PLANNING AMENDMENT

Application No. *H14/0079/99*

*FORMER ABATTOIR PREMISES
KNIGHT STREET, PINCHBECK, Lincs.*

*PROPOSED CHANGE OF USE
(PART OF BUILDING) TO MEAT PRODUCT
FACILITY.*

980803 / P2

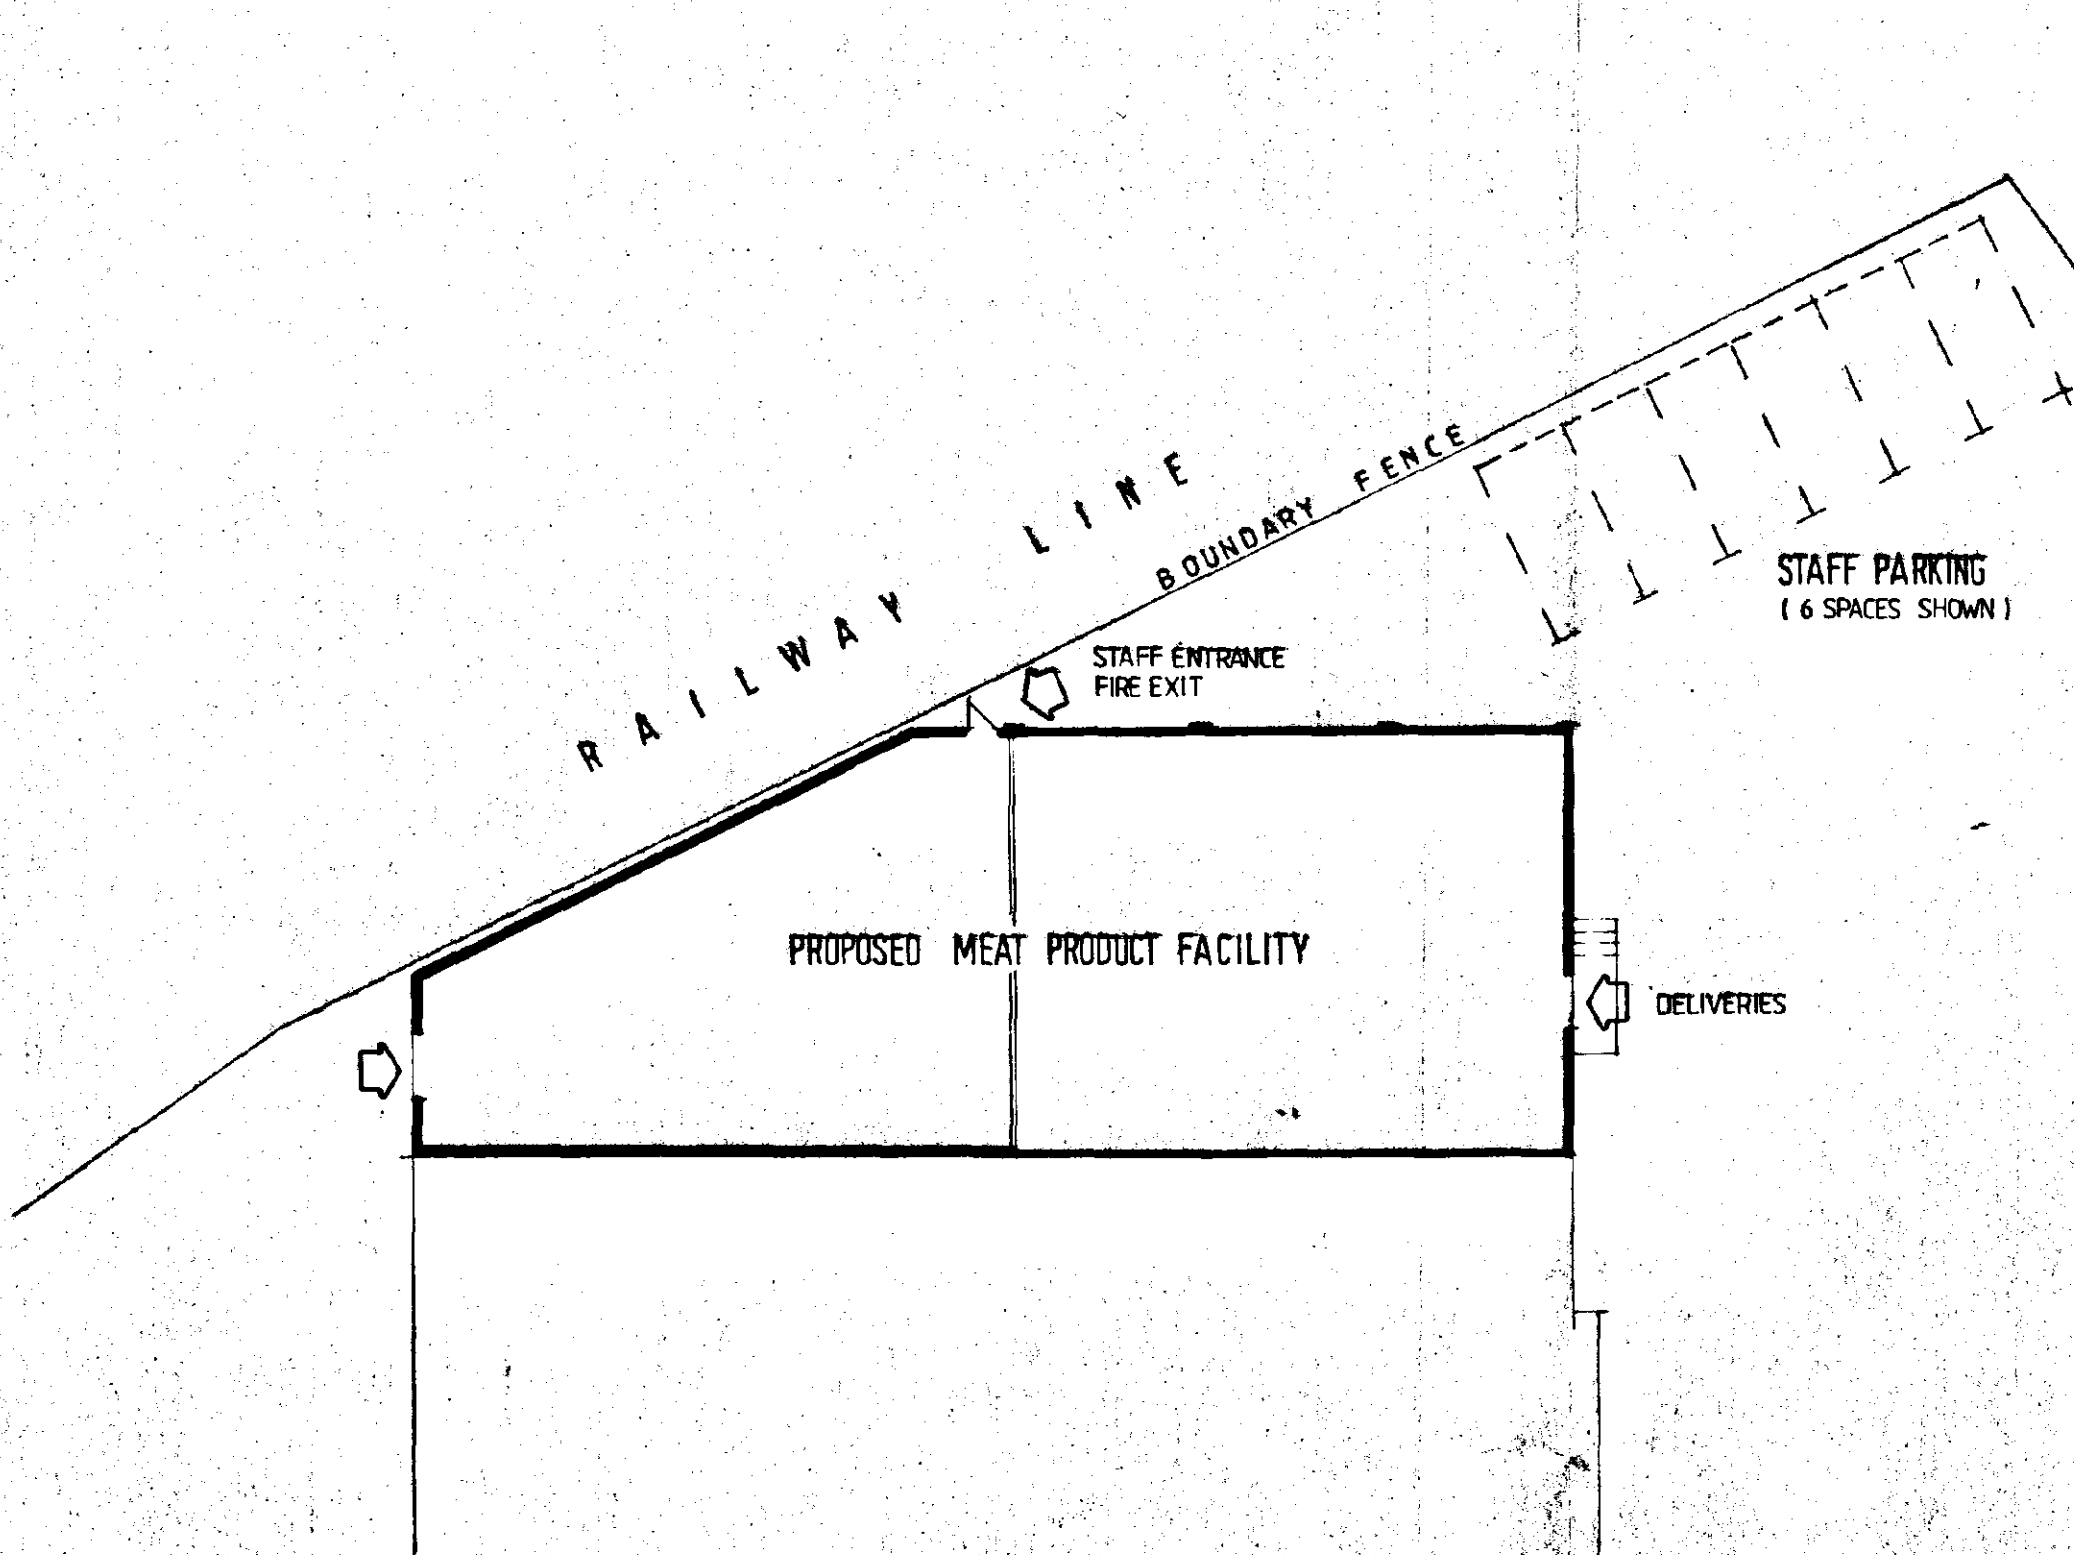
*STAFF PARKING ARRANGEMENT
AS REQUESTED BY L.C.C. HIGHWAYS*
